Comments by arboricultural consultant 12/10/2026

Tree Protection Plan			
Client			
Site/Project			
Long Lane, Earlsheaton			
Scale/Sheet		Date	
1:200 - A1		15/06/2026	
Drawing No	Rev	Drawn By	Checked By
	1	DB	SS

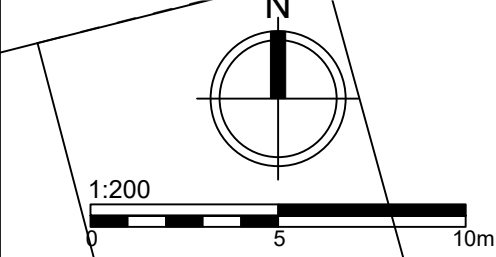
"The response notes the retaining wall construction, tree protection fencing, RPA ground-level changes, fill material and aeration are already incorporated within the submitted AMS. It looks like the only query is the requirement for the AMS/TPP to identify the special engineering measures associated with the proposed hardstanding encroachment into the RPA of G5, to reduce impacts upon the retained trees.

As it stands, the methodology will be treated the same as the retaining wall construction, with the AMS stating the construction of the retaining wall boundaries along the east and south boundaries.

The arboricultural impact first arises from the increase in ground levels rather than from the subsequent construction of the road itself, in which the AMS already provides mitigation for this, requiring an aeration system, such as perforated piping, where ground levels are raised by more than 150mm within an RPA, to maintain air and water movement through the fill.

As such, no additional special engineering specification for the road construction itself is considered necessary from an arboricultural perspective, as the principal impact has been addressed through the ground-level increase and associated aeration measures"
